DECISION DELEGATED TO HEAD OF PLANNING

Application No: H16-0928-22 **Applicant:** Specsavers Optical Stores

Proposal: Proposed alterations to shopfront

Location: 31 Hall Place Spalding

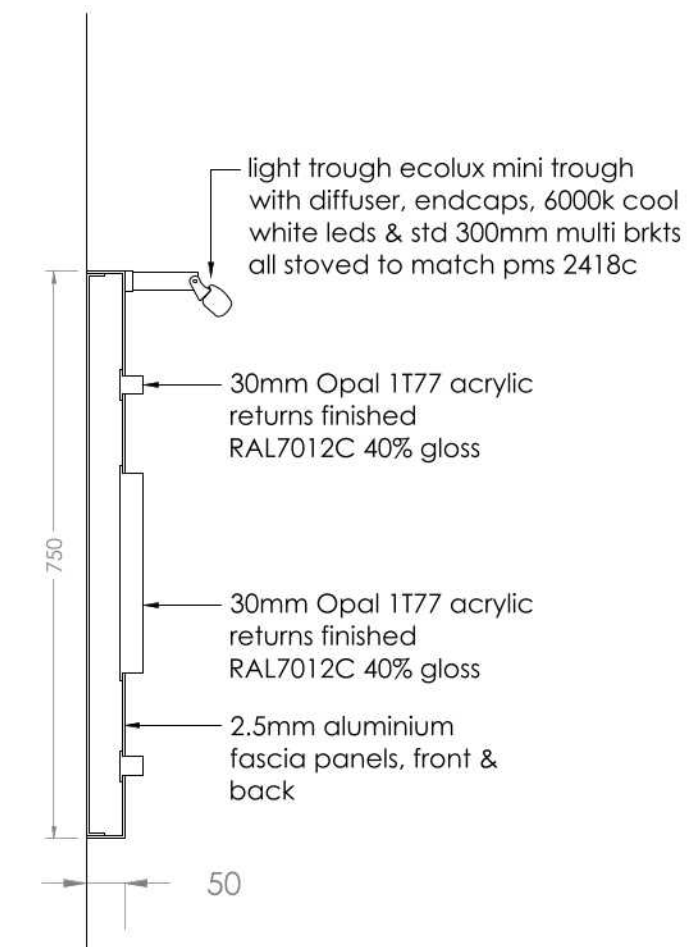
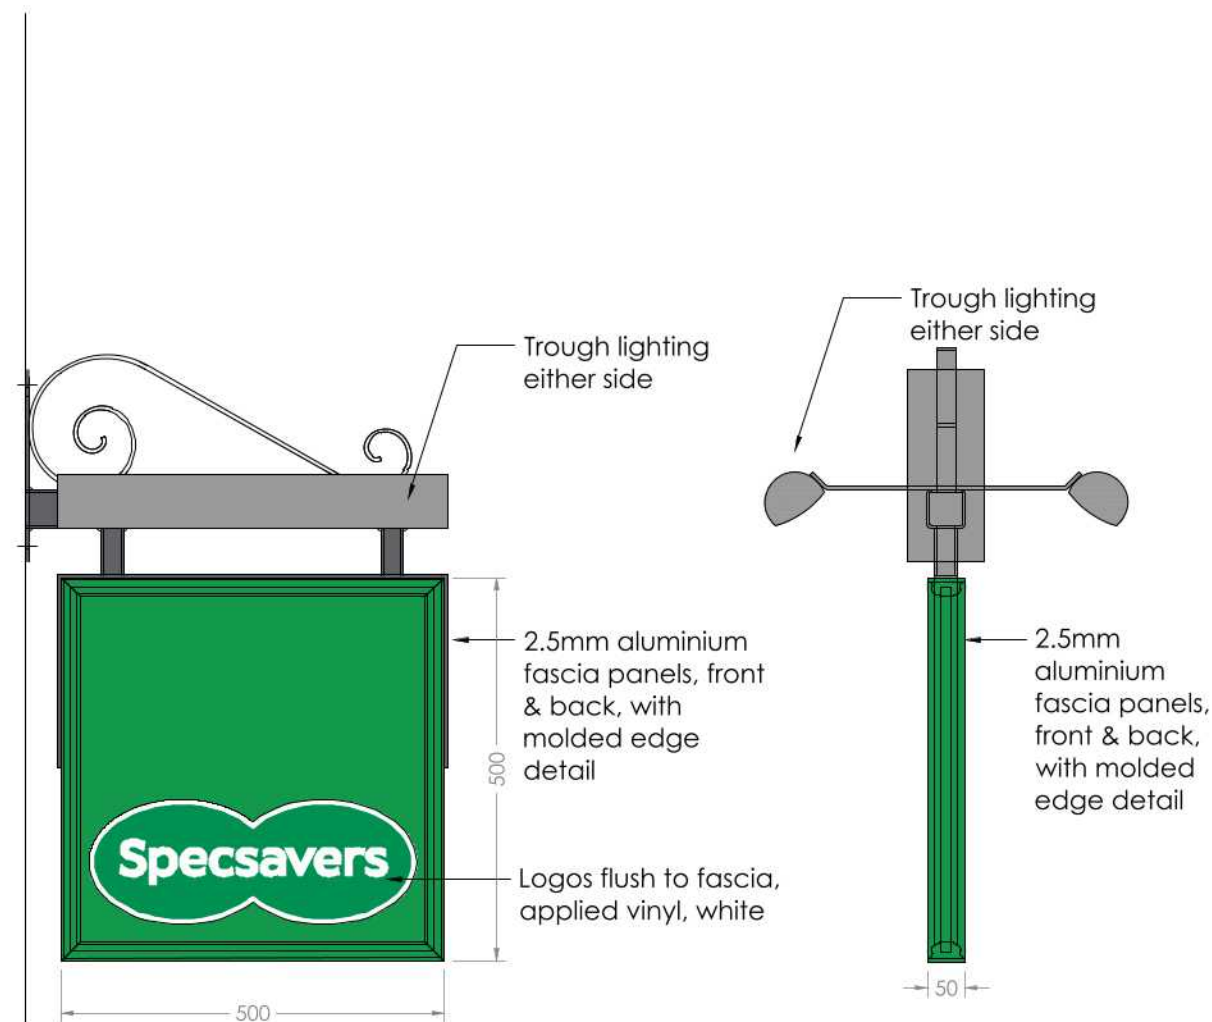
The Civic Society commented on the accompanying advertisement consent application. Their comment questions whether the corrugated/profiled cladding should be retained and covered by the proposed aluminium baseboard, or whether it would be more suitable to remove it entirely.

The Civic Society has raised a concern asking to consider whether the profiled cladding which is to be covered by the proposed signage ought to be removed rather than covered. The covering of the profiled material is not considered to be a negative impact upon the setting and the additional profile of the proposed signage is not considered a material detractor from the arguments for the proposal and therefore is not a sufficient basis upon which to require an amendment or refuse permission.
